**From:** Silvie Steiningerova  
**Sent:** 18 August 2026 11:31  
**To:** Planning.Responses  
**Subject:** FW: Y/47/26/HH- Flints, Hoe Lane  
**Attachments:** Heritage Statement.pdf

**From:** Jack Dowling [REDACTED]  
**Sent:** 12 August 2026 13:41  
**To:** Silvie Steiningerova <[Silvie.Steiningerova@arun.gov.uk](mailto:Silvie.Steiningerova@arun.gov.uk)>  
**Subject:** RE: Y/47/26/HH- Flints, Hoe Lane

**Subject:** Y/47/26/HH- Flints, Hoe Lane

Existing North Elevation

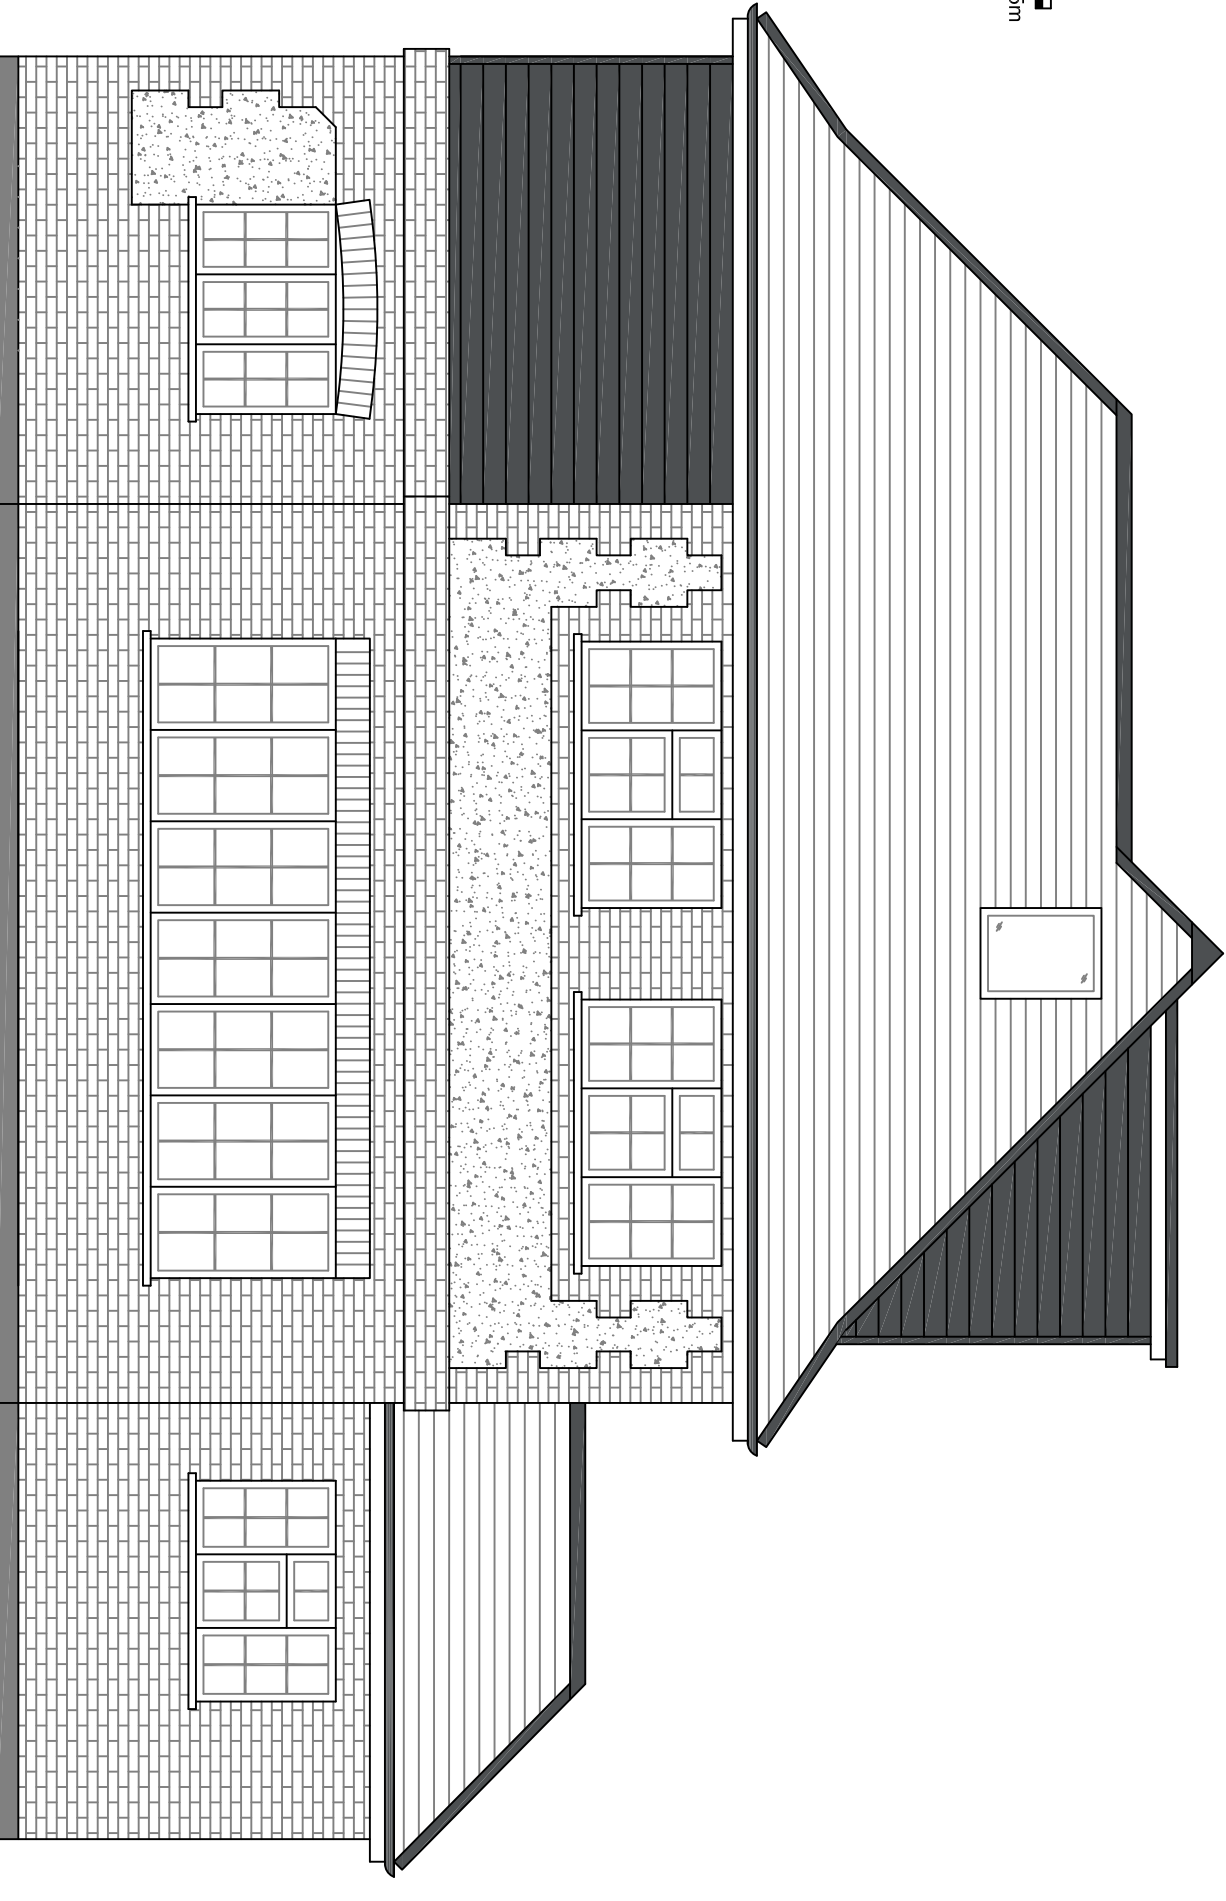
I visited the site today and noted that the dormers are currently under construction and have not yet been completed. As such, the submitted drawings and application description do not accurately reflect the existing dwelling.

The submitted existing drawings appear to show alterations that were submitted under the previous permission and I want to ensure that the existing drawings accurately reflect the dwelling as it currently exists on site.

The dormer and first floor extension have been implemented, just the ground floor was smaller than they wanted so that's been resubmitted. Thanks
